NEATH PORT TALBOT COUNTY BOROUGH COUNCIL

WRITTEN REPRESENTATIONS

Power Generation Enhancement scheme at
Port Talbot Steel Works, Margam.

PINS REFERENCE: EN010062

Client: **THE PORT TALBOT STEELWORKS (POWER GENERATION ENHANCEMENT) ORDER**  
 Project:  
 Title: **INDICATIVE ELEVATIONS - GENERATING STATION**

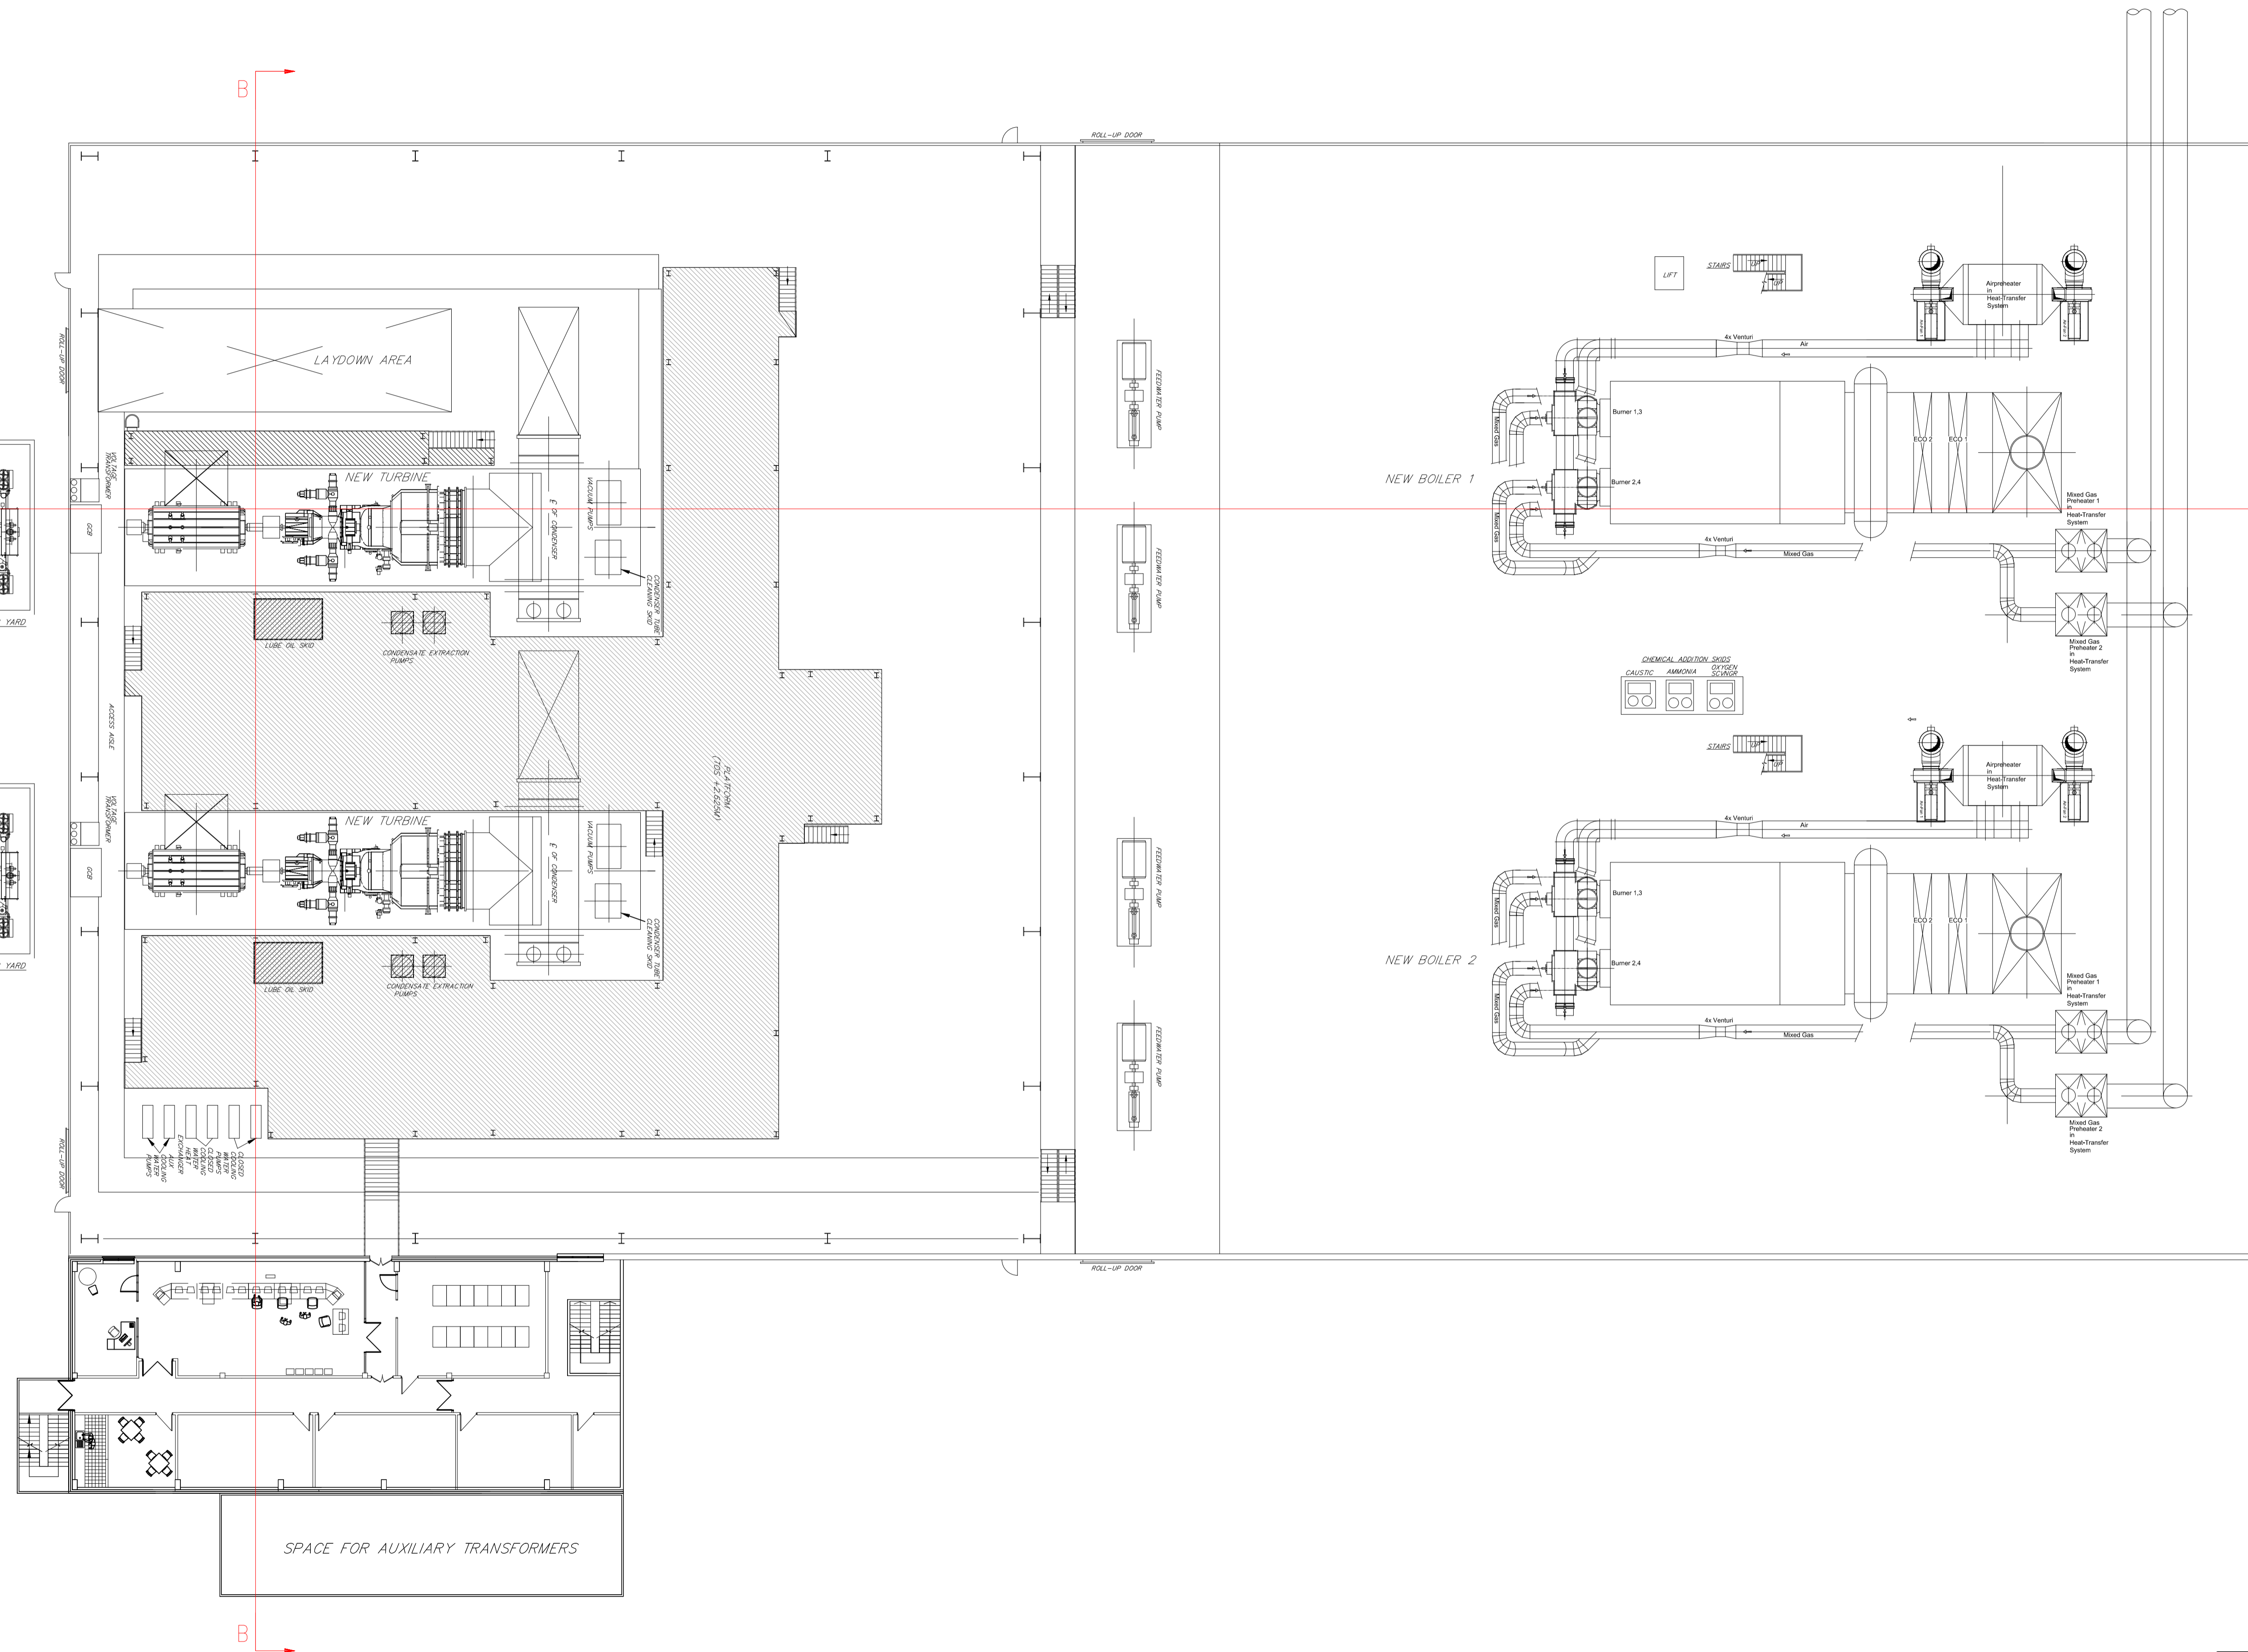
4. In this regard, the Council is concerned that the illustrative drawings and photomontages submitted with this application to date do not demonstrate the clarity of design thought expected for a scheme of such magnitude, with such potential for significant landscape and visual impact, or reflect the acknowledged recognition in the ES that good design of the buildings associated with the development is an essential requirement.

5. Accordingly, providing extensive and detailed consideration is given to a scheme of the highest quality in terms of design, use of materials and landscaping, (whether as two distinct phases or a single proposal), and that the applicant is able to demonstrate that commitment through additional submissions, it is considered that the proposed development would be unlikely to result in any significant detrimental impact in terms of visual amenity and has the potential to become a key landmark building which could enhance the appearance of this area of Port Talbot.
